ITEM 1.2 (c)

Issue/ Objection:
Solar Access

85 Harrington Street
The Rocks
GOLDEN AGE & HANNAS THE ROCKS

TITLE
RESPONSE TO DoPE
ITEM 1.2 (c)

TITLE
**Diagrams
Solar Access**

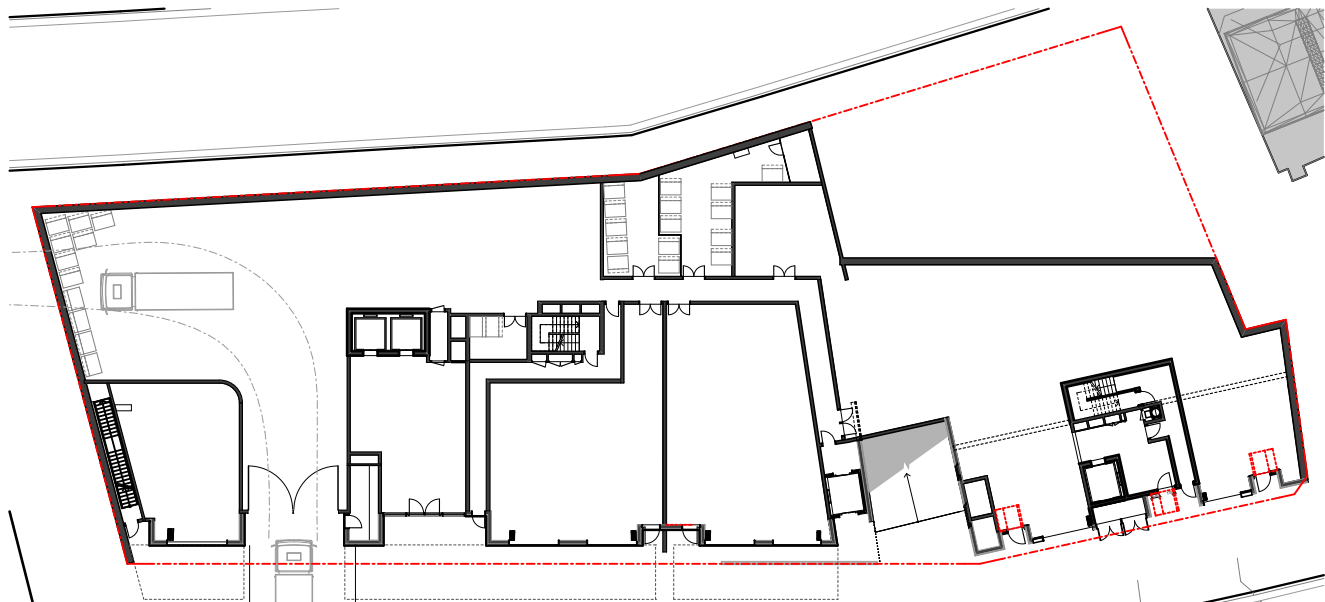
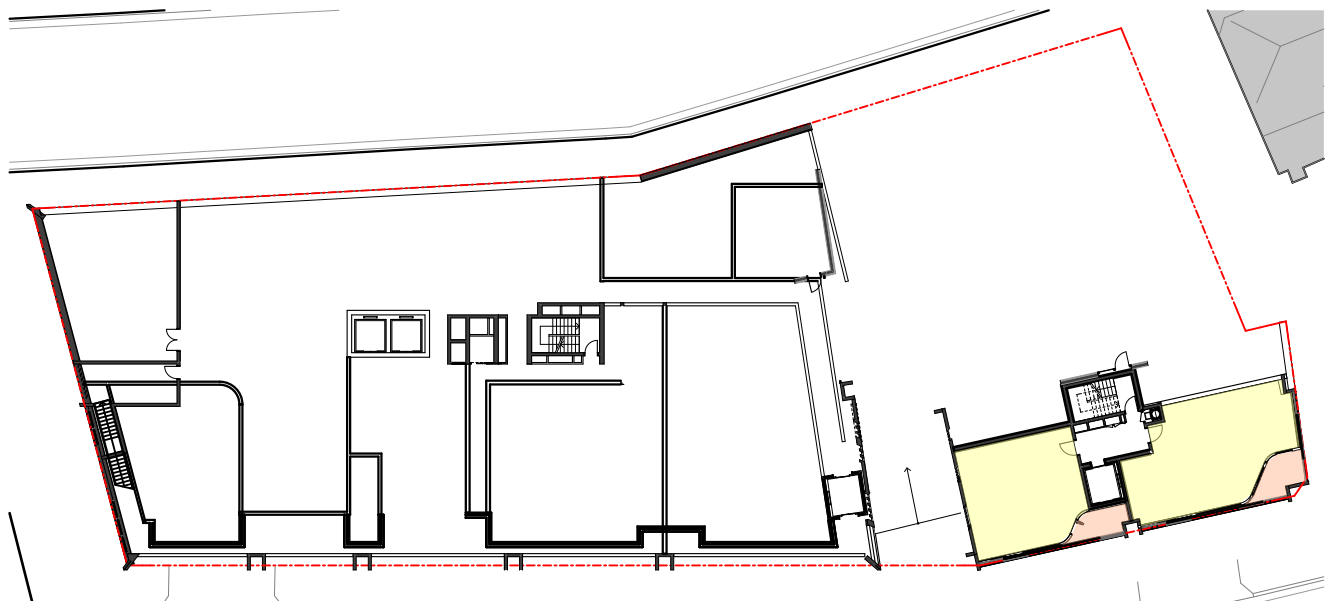
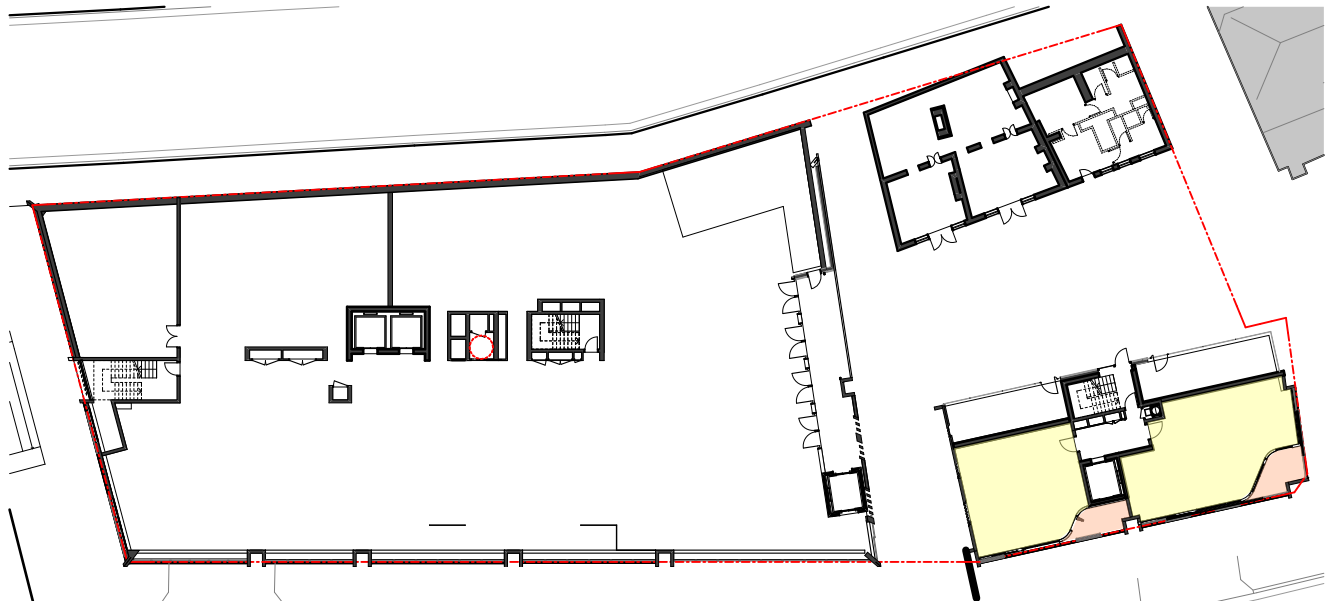
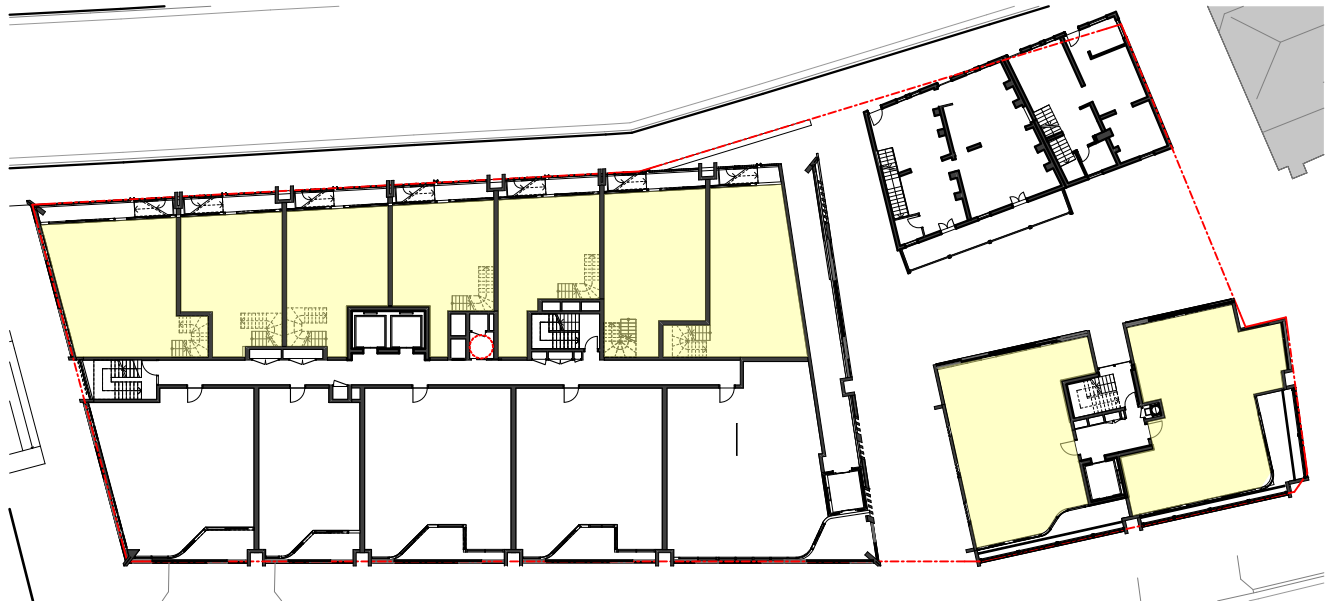
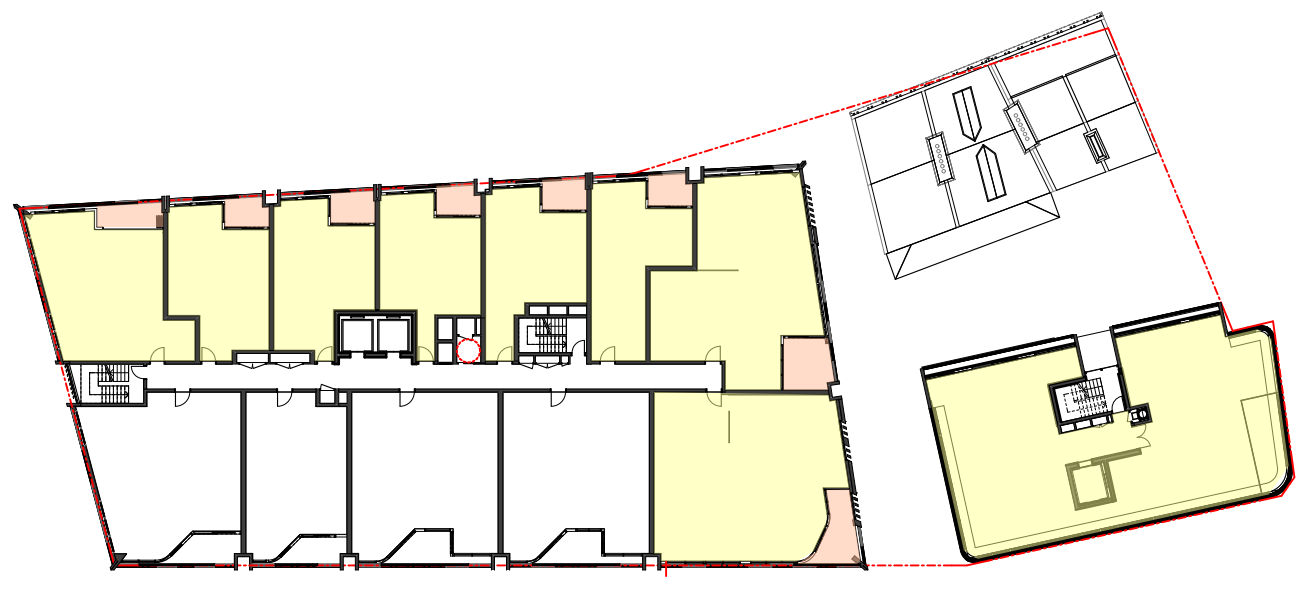
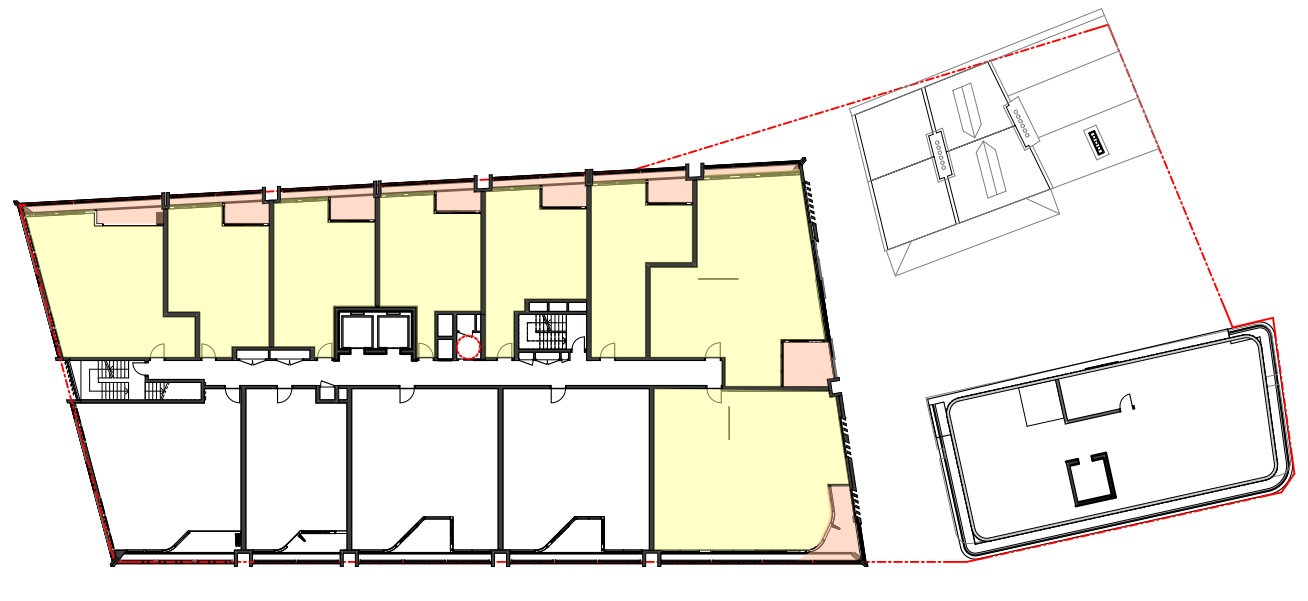
Description:
The proposal indicates 70% of units will receive at least two hours solar access in midwinter (9am to 3pm) and all units will receive at least one hour of solar access in midwinter. Please provide a solar access study demonstrating the above including consideration of the proportion/area of the living rooms and balconies receiving solar access.

Response
The site is located in a dense, urban, city setting. The topography of the site relies upon a design response resulting in a building with a North/South orientation. As such all apartments face an East or West direction and are afforded good solar amenity. The building results in **no single aspect south facing apartments**. An extensive solar access study has been undertaken to show that 70% of units will receive atleast 2 hours solar access in midwinter (9am to 3pm)
